From: Kathryn Griffiths [REDACTED]
Sent: 05 February 2019 11:43
To: Simon Davis
Cc: Zoe Knott
Subject: Burndell Road - Y/98/18/RES / Y/97/18/DOC

Thank you for the telephone conversation last Tuesday (29th) where you raised your initial concerns which we have addressed below.

PRELIMINARY ENGINEERING LAYOUT

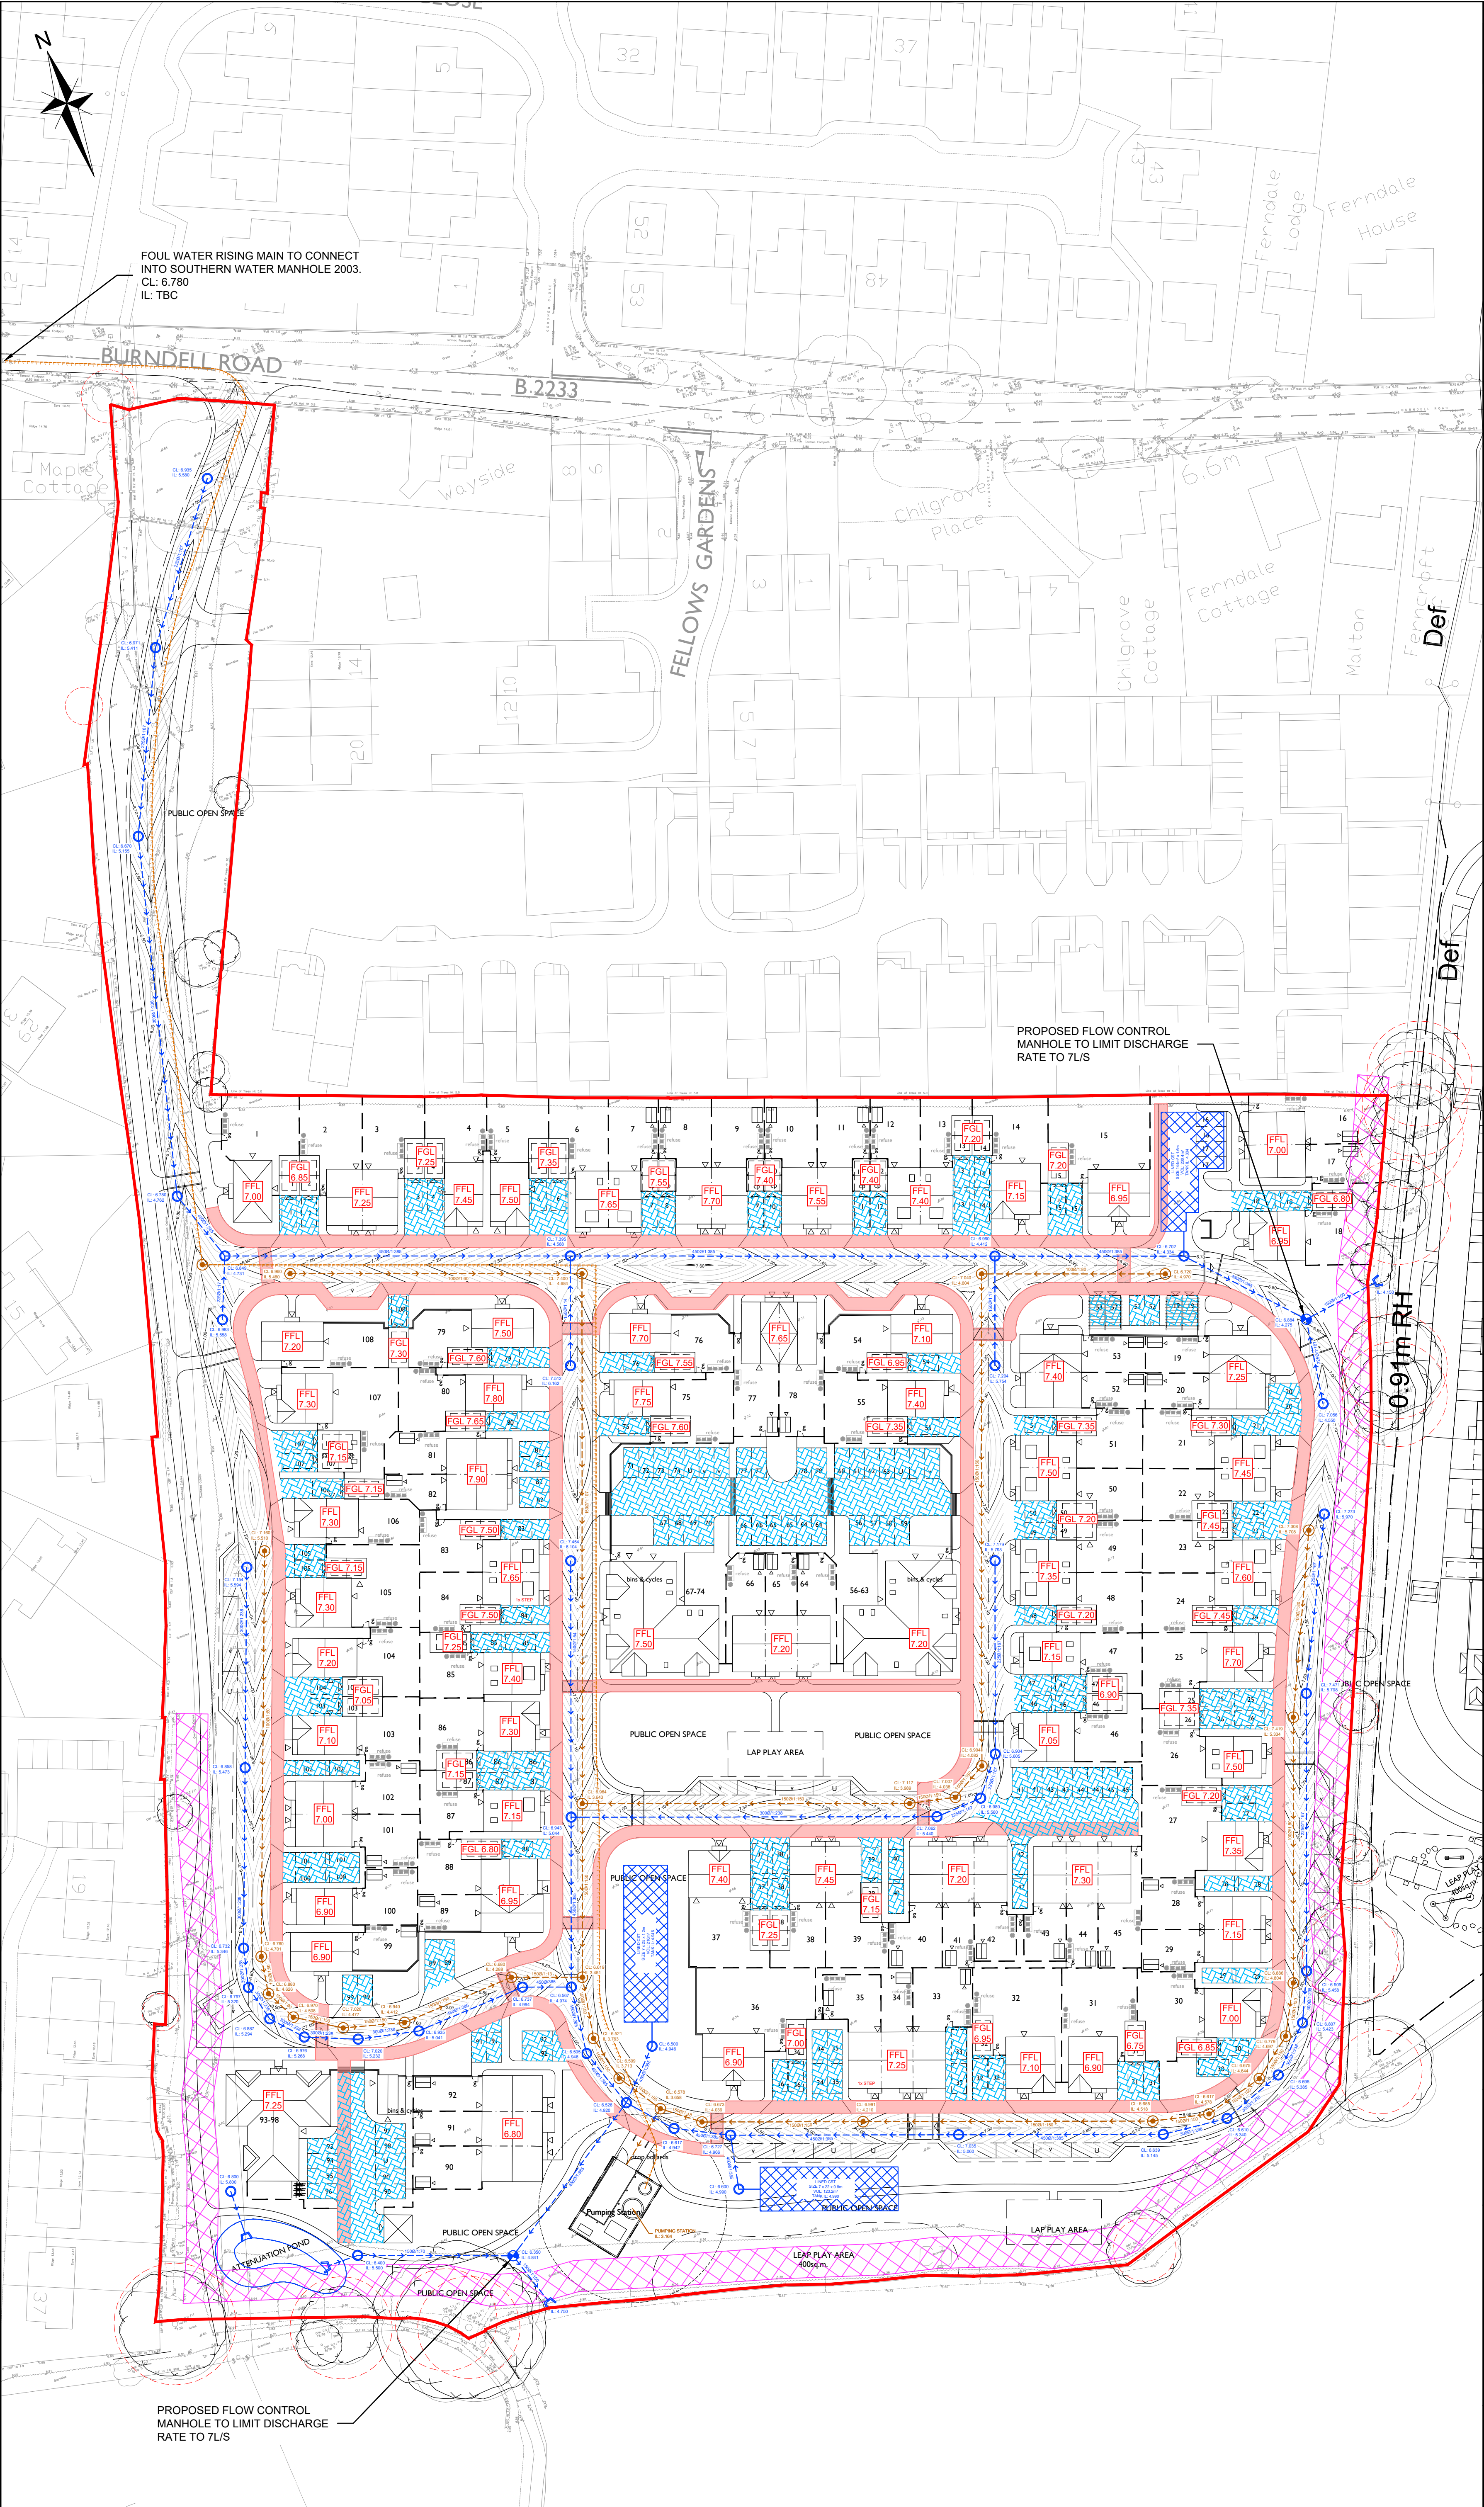
The proximity of the trees to the attenuation ponds in the south west corner is currently being reviewed and will be addressed as part of the landscaping and drainage comments made by the Council.
